Rezoning Transportation Analysis

Petition Number: 2021-092

Date	Description
06-01-2021	First Review (KP)

NO.	REVISIONS	DATE	BY

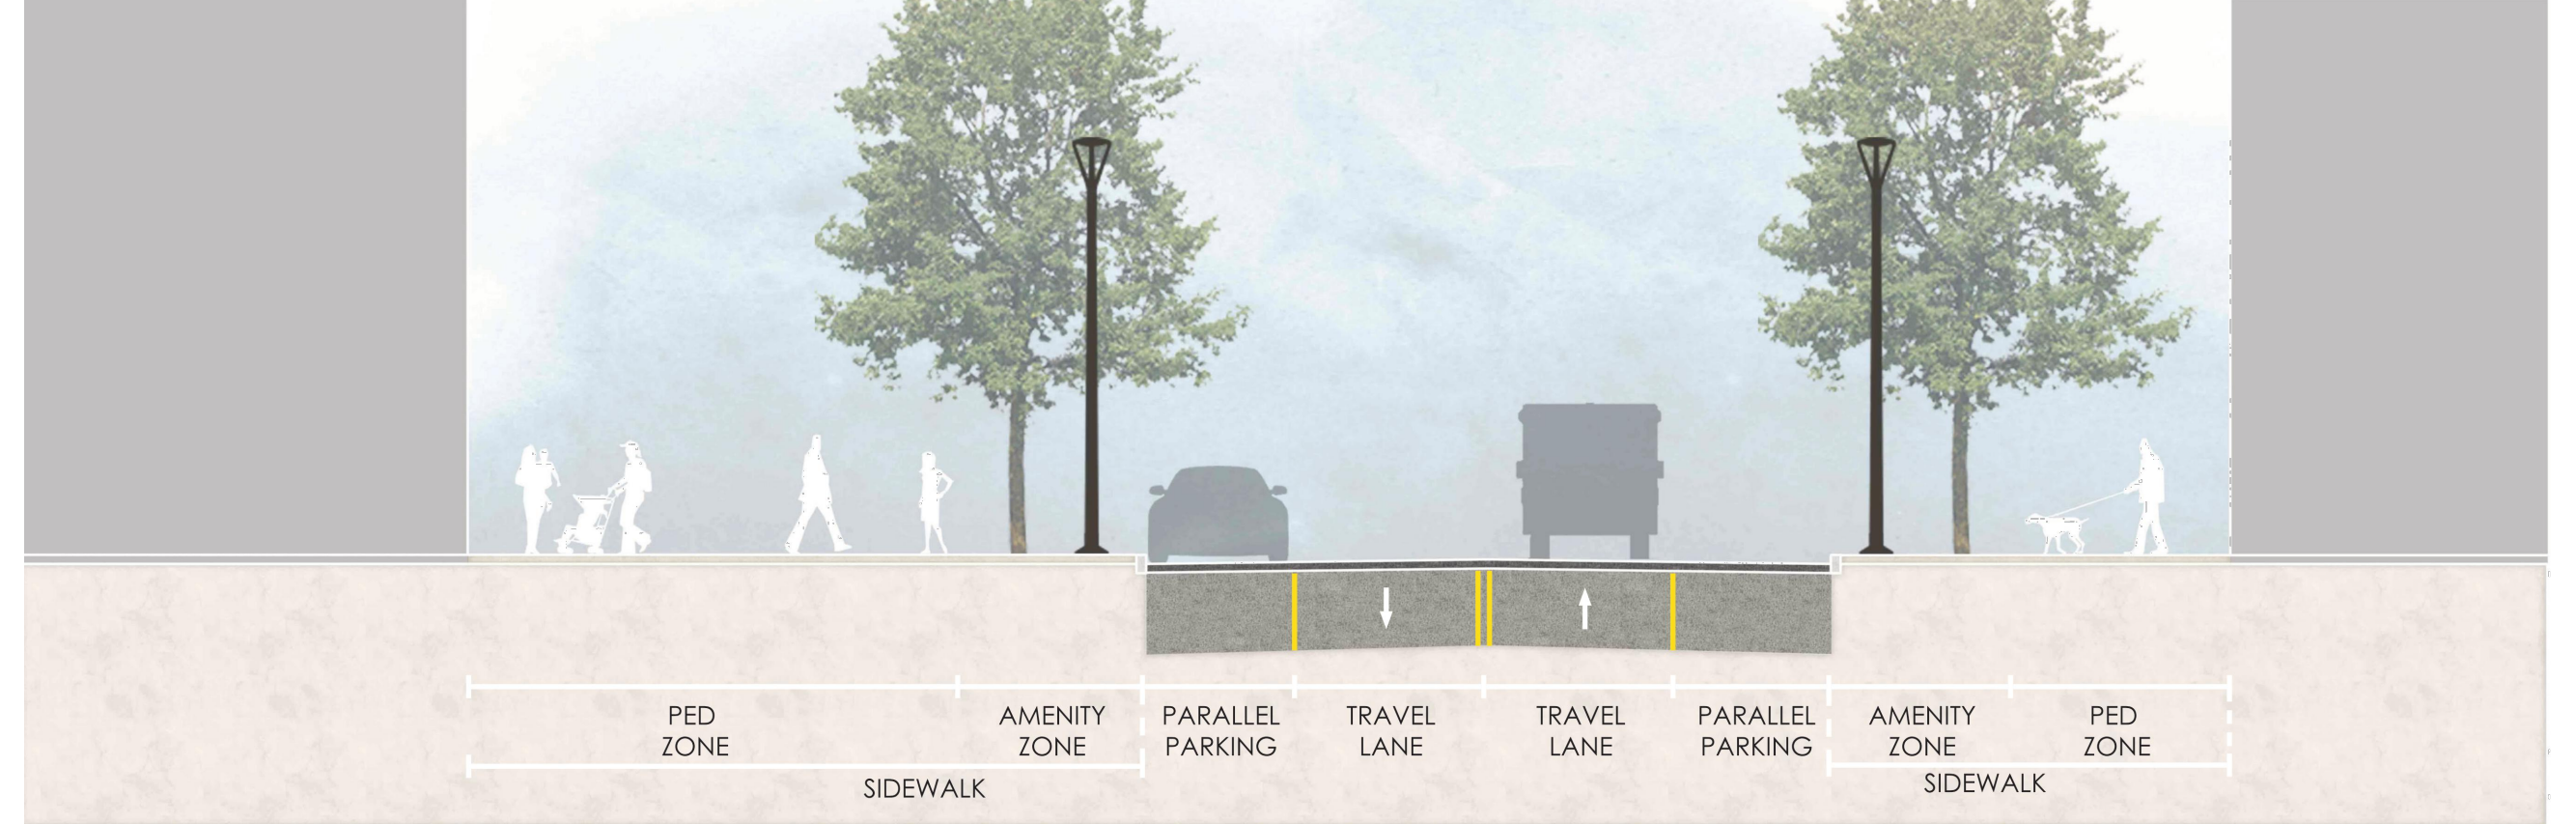
1. **Curb line:** The proposed zoning district has a setback measured from back of the existing or proposed future curb line. Revise Sheet RZ-1.1 by adding the curb line dimensions to the cross sections provided. Please note: The following curb line dimensions proposed are conceptual and may be altered as coordination with CDOT throughout the rezoning process ensues.

- a. **Morehead Street:** The location of curb and gutter will be moved and located 38-feet from the existing centerline to the back-of-curb.
 - b. **McDowell Street:** The future location of curb and gutter is in the existing location.

- c. **Baxter Street (Section C-C)** – The location of curb and gutter will be moved and located to 21.5-feet from the existing centerline to each back-of-curb.

- d. **Baxter Street (Section D-D)** – The location of curb and gutter will be moved and located to 19-feet from the existing centerline to each back-of-curb.

- e. **Baxter Street Extension (Section E-E)** – The location of curb and gutter will be moved and located to 21.5-feet from the existing centerline to each back-of-curb.

- f. **Proposed Public Street (Section F-F)** - The location of curb and gutter will be located 18.5-feet from the proposed centerline to each back-of-curb.

3. **Right-of-way and Other Infrastructure Dimensions:** Revise Rezoning Sheet RZ-1.1 to include detailed dimensions for each infrastructure item, and the total right-of-way for the cross sections shown. Refer to the USDG Cross sections and on-street parking details, located within the Charlotte Land Development Standards Manual, to determine the appropriate widths associated with each infrastructure item and the cross sections' total widths. Revise the site plan sheets by clearly labeling each public and private street section as well as each access point. Labeling each street section and access point will allow for thorough comments throughout the rezoning and permitting process. CDOT prefers the separated cycle track and sidewalk for McDowell Street (cross-sections A-A and B-B). Please note: The following right-of-way dimensions proposed are conceptual and may be altered as coordination with CDOT throughout the rezoning process ensues.

- a. **Morehead Street:** 56-feet of right-of-way dedication measured from the existing road centerline.
 - b. **McDowell Street:** 110-feet of total right-of-way dedication, 55-feet measured from the existing road centerline to each right-of-way line.

- c. **Baxter Street (Section C-C)** – 93-feet of total right-of-way dedication, 46.5-feet measured from the existing road centerline to each right-of-way line.

- d. **Baxter Street (Section D-D)** – 86-feet of total right-of-way dedication, 43-feet measured from the existing road centerline to each right-of-way line.

- e. **Baxter Street Extension (Section E-E)** – 93-feet of total right-of-way dedication, 46.5-feet measured from the existing road centerline to each right-of-way line.

- f. **Proposed Public Street (Section F-F)** - 73-feet of total right-of-way dedication, 36.5-feet measured from the existing road centerline to each right-of-way line.

4. Revise the Rezoning Sheet RZ-1.0 and RZ-1.1 by establishing a cross section associated with the proposed private street connecting McDowell Street to Baxter Street Extension. Include the cross section on Rezoning Sheet RZ-1.1.

Plotted By: Whitesell, Andrew Sheet: Sst: Atrium - C/C Resoning Layout: RZ-1.3 PED AND BIKE CONNECTIVITY - March 26, 2021 12:19:23pm \\kimley-horn.com\SE_CHL\CHL_PRA\016031_Carolina Healthcare System\128_C/C Resoning and Design\02 - DWG\PlanSheets\1-0 - Rezoning_RZ-1.3 PED BIKE CONNECTIVITY.dwg

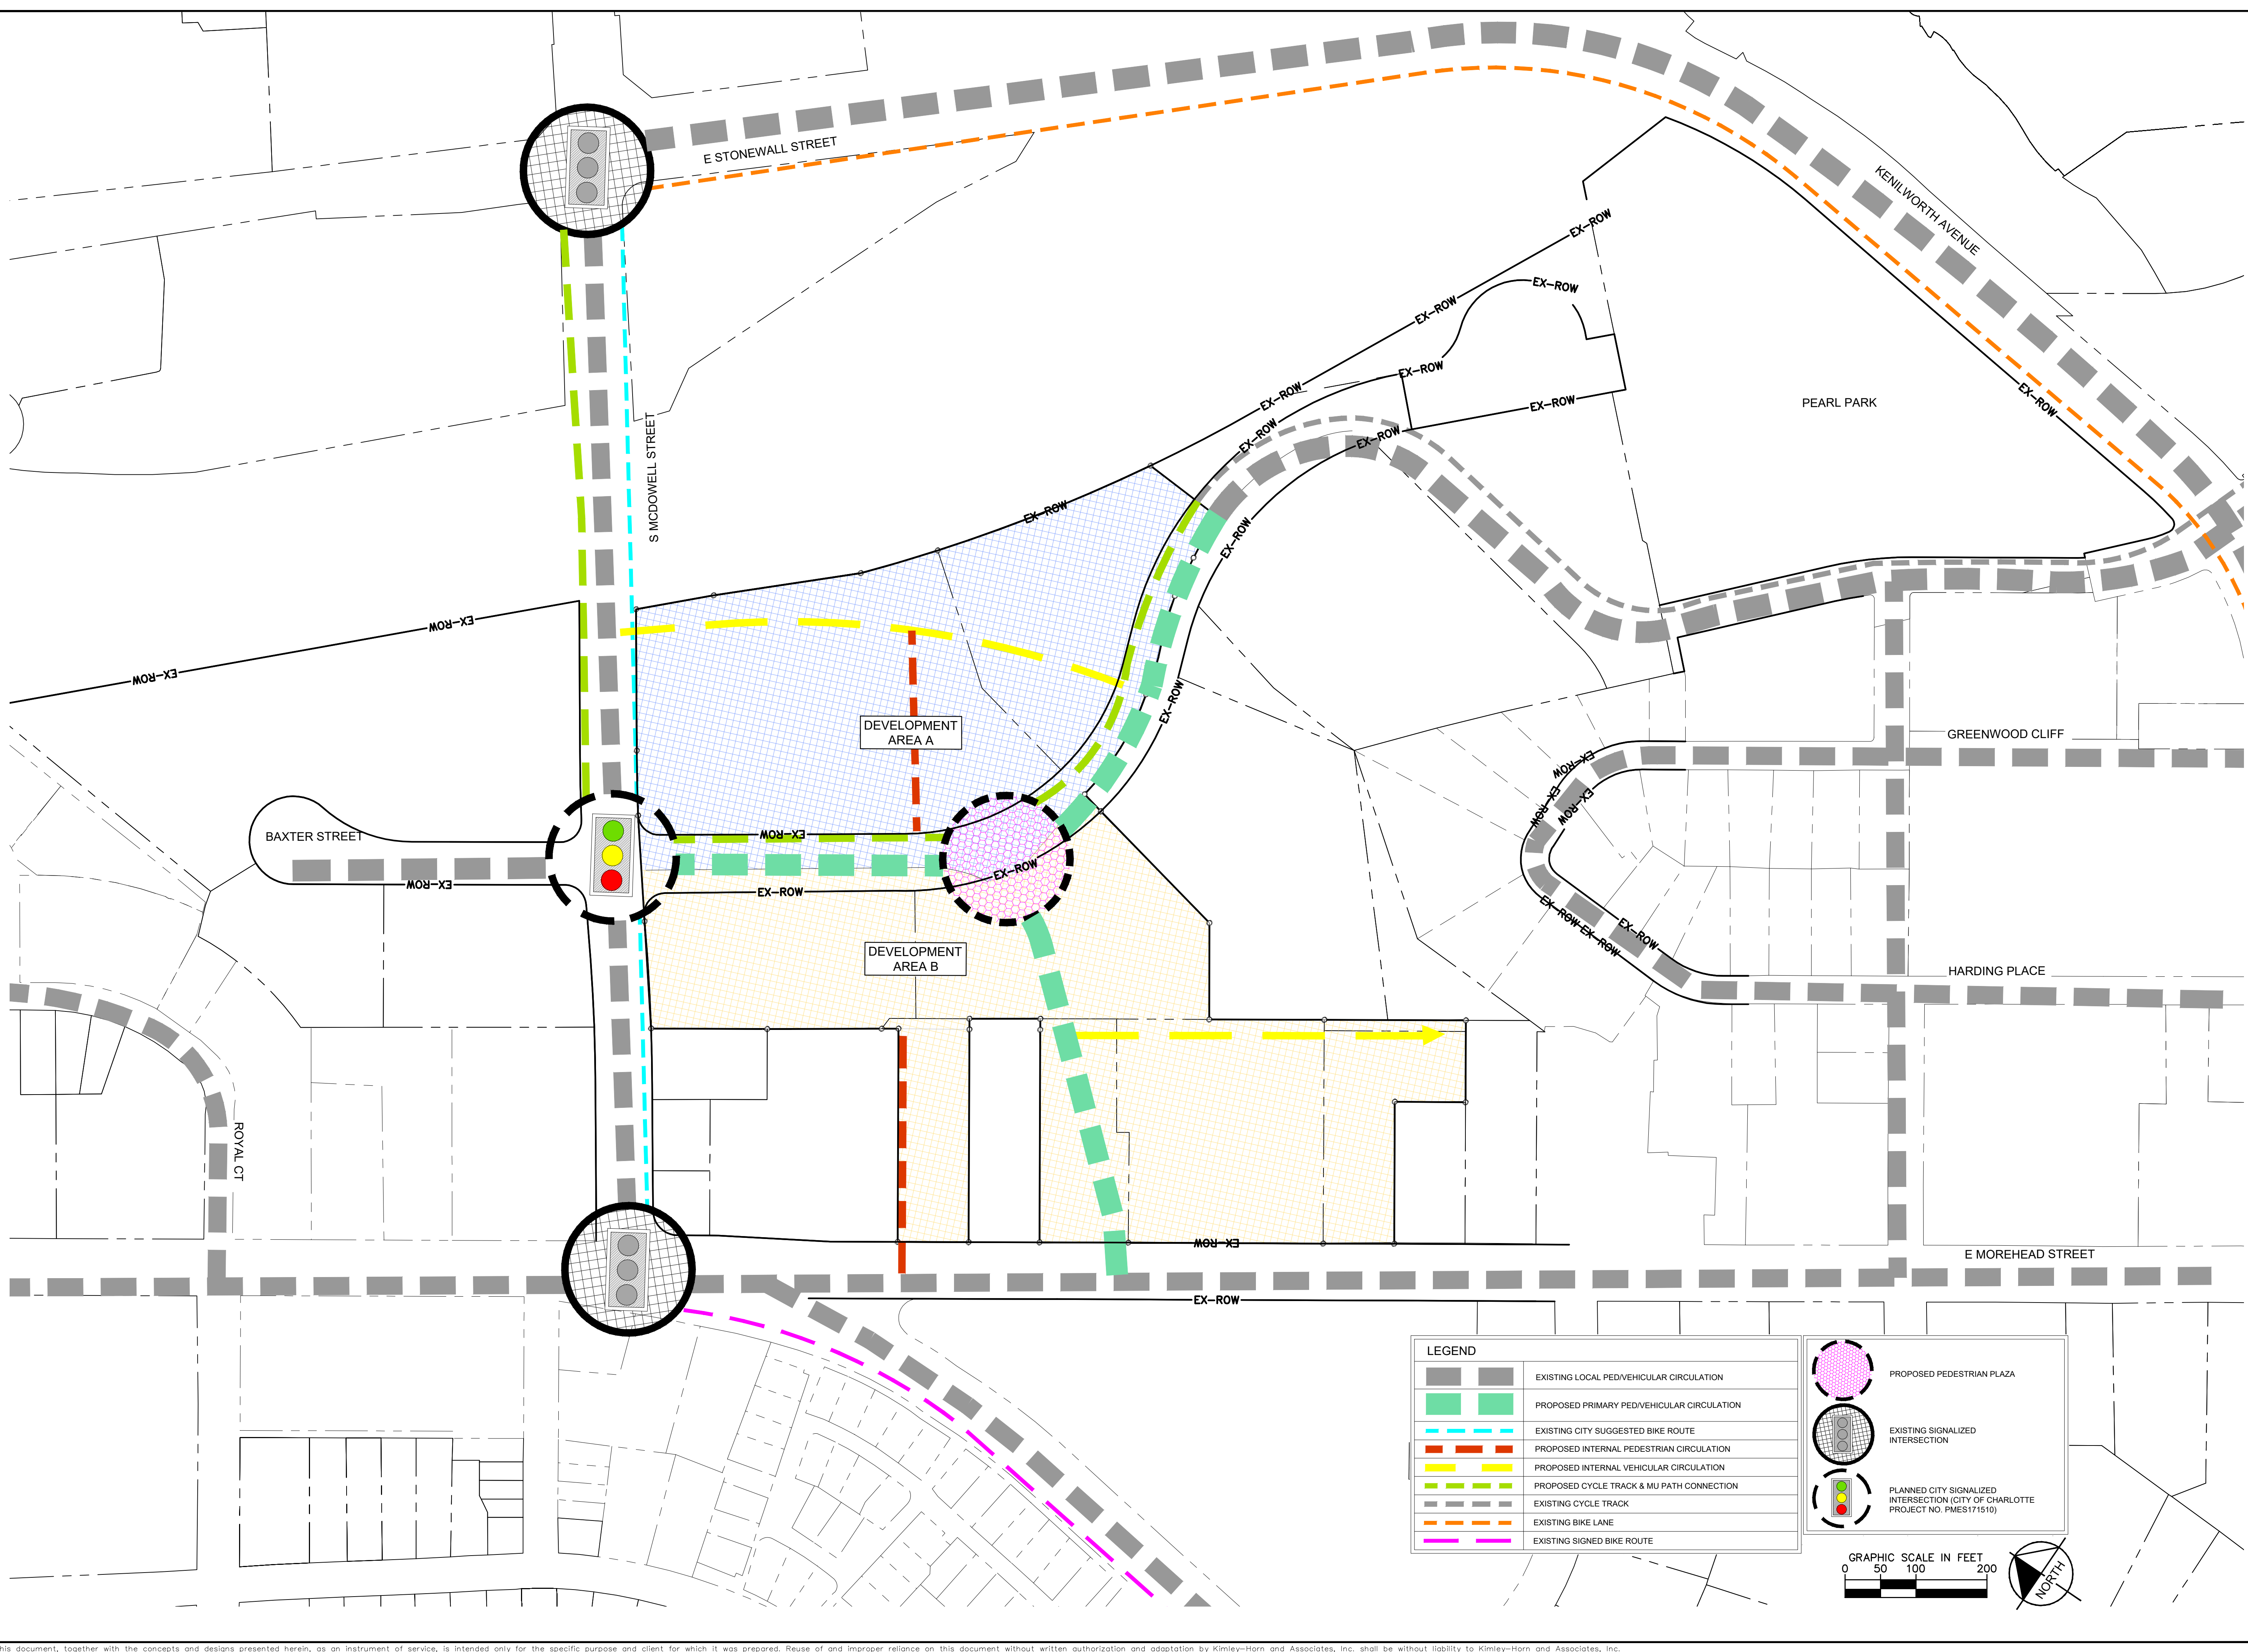
Sheet RZ-1.3 – Ped and Bike Connectivity

5. Revise the site plan sheets and conditional notes by committing to connect the roadway improvements, pedestrian improvements, and the proposed cycle track associated with the Baxter Street Extension, Cross Section E-E, to the relative infrastructure associated with the Pearl Parkway Extension, SDRMUR-2020-00026.
